INTER-OFFICE MEMO

RE: Project #2022-007219/SI-2022-01478 and VA-2022-00235,
Site Plan-EPC Major Amendment and Variance-EPC
Wyoming Apartments- Titan

Note: Staff reviewed the DFT version of the Site Plan-EPC against the EPC version of the Site Plan-EPC, which is the standard, required review.

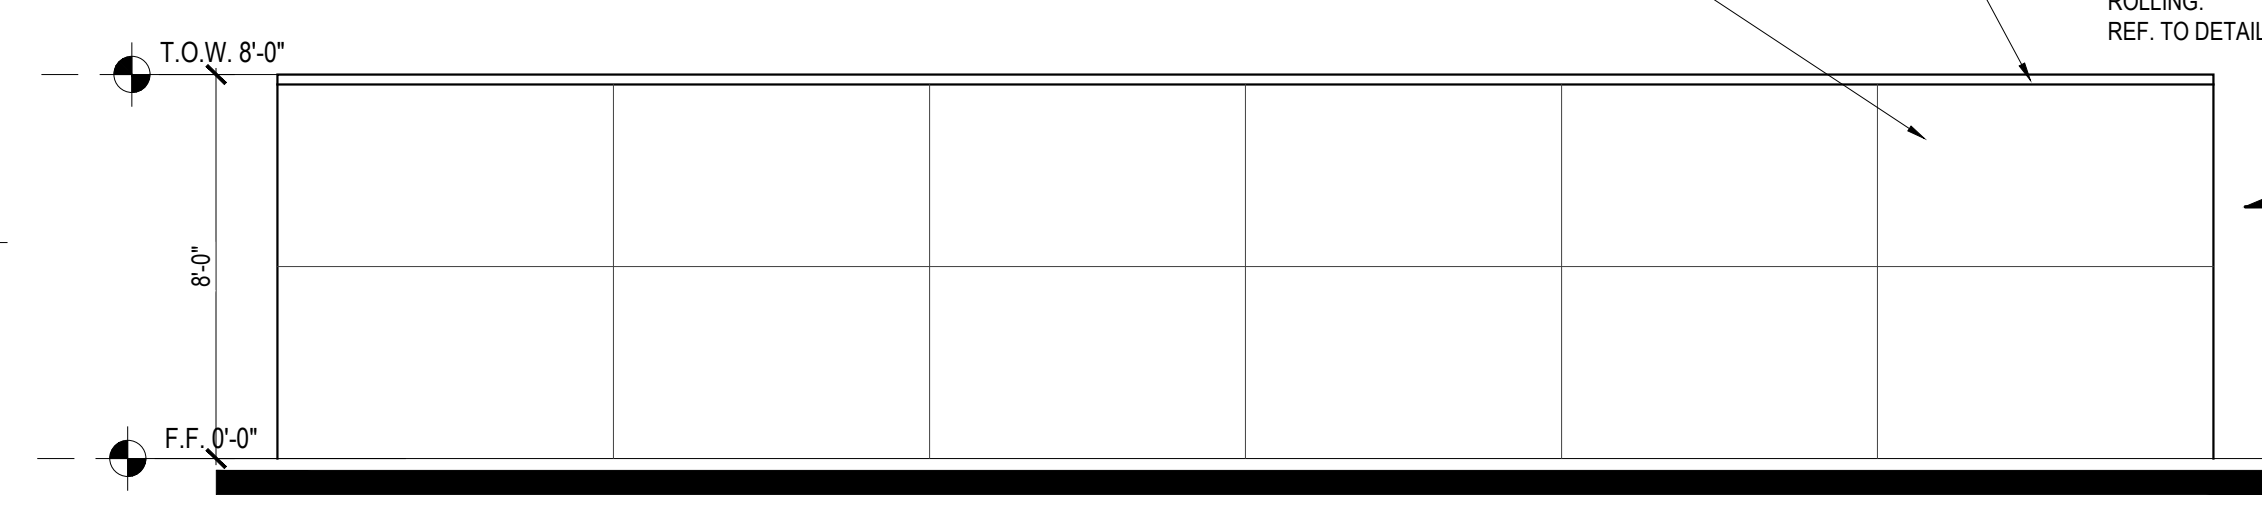
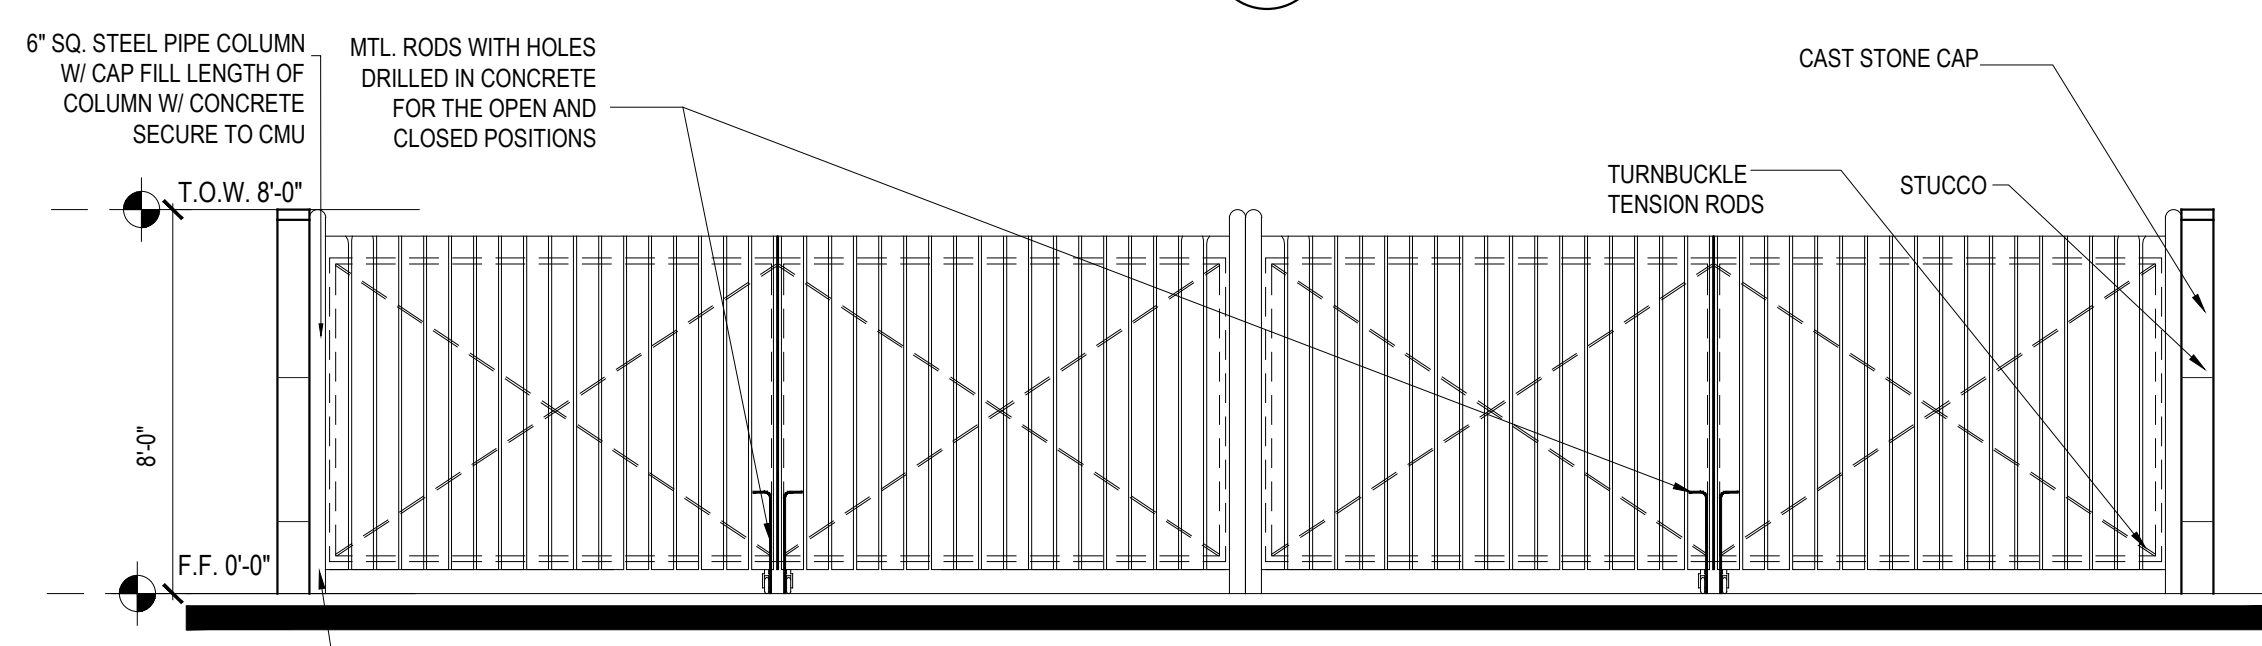
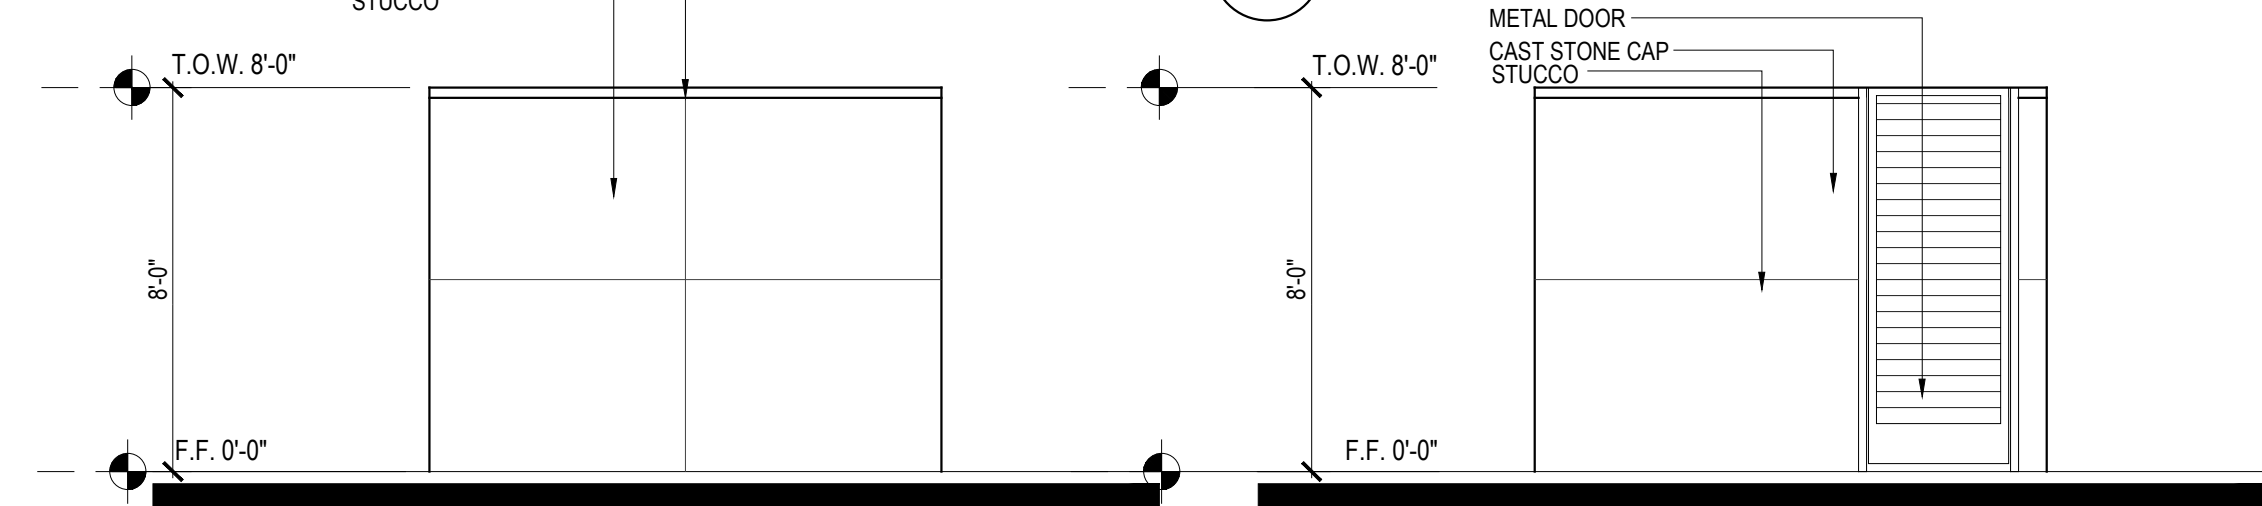
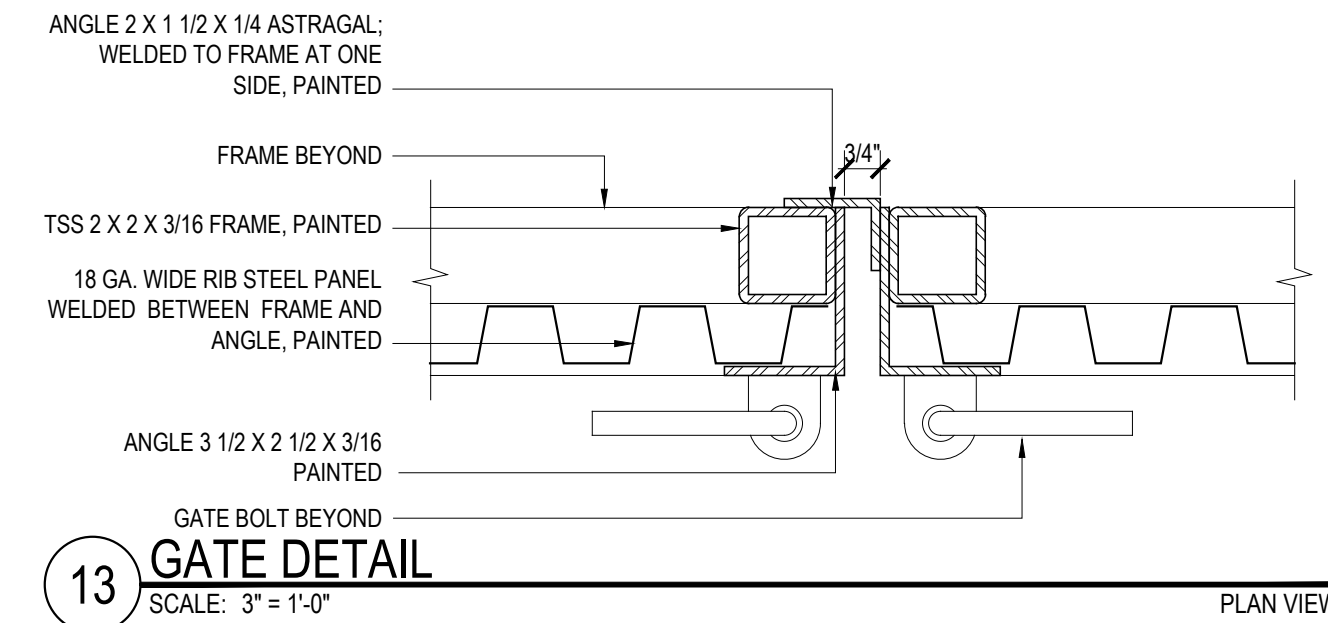
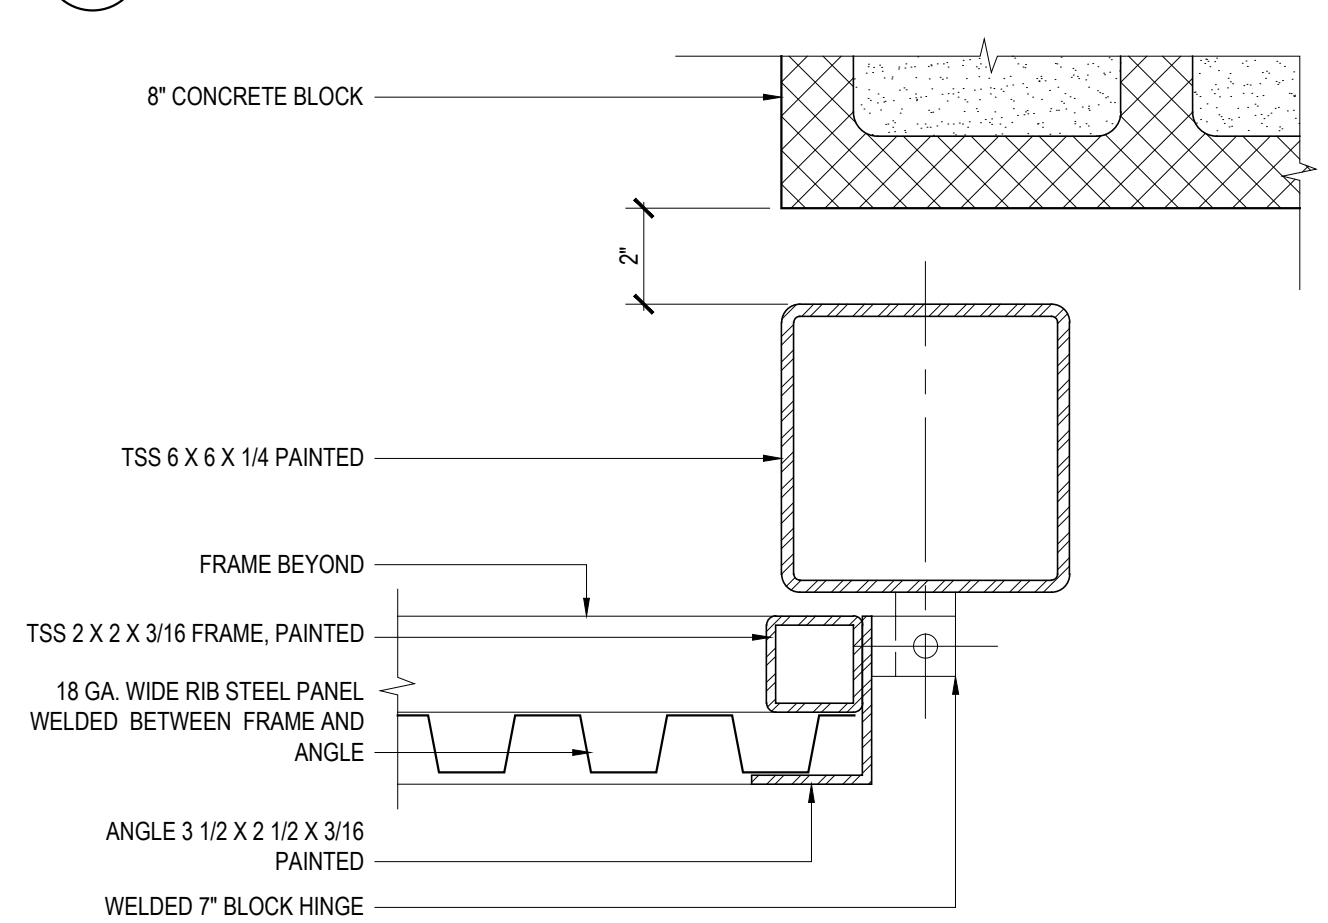
3. Condition 5: Same as Condition 4C: the keyed notes referred to in the memo, for pedestrian access, appear to be incorrect.
4. Condition 6- refuse enclosure: The EPC site plan set did not contain detail sheets (it should have) as part of the EPC review. The refuse enclosure detail in the DRF set does not indicate color of the block, stucco, or color and material of the gates.
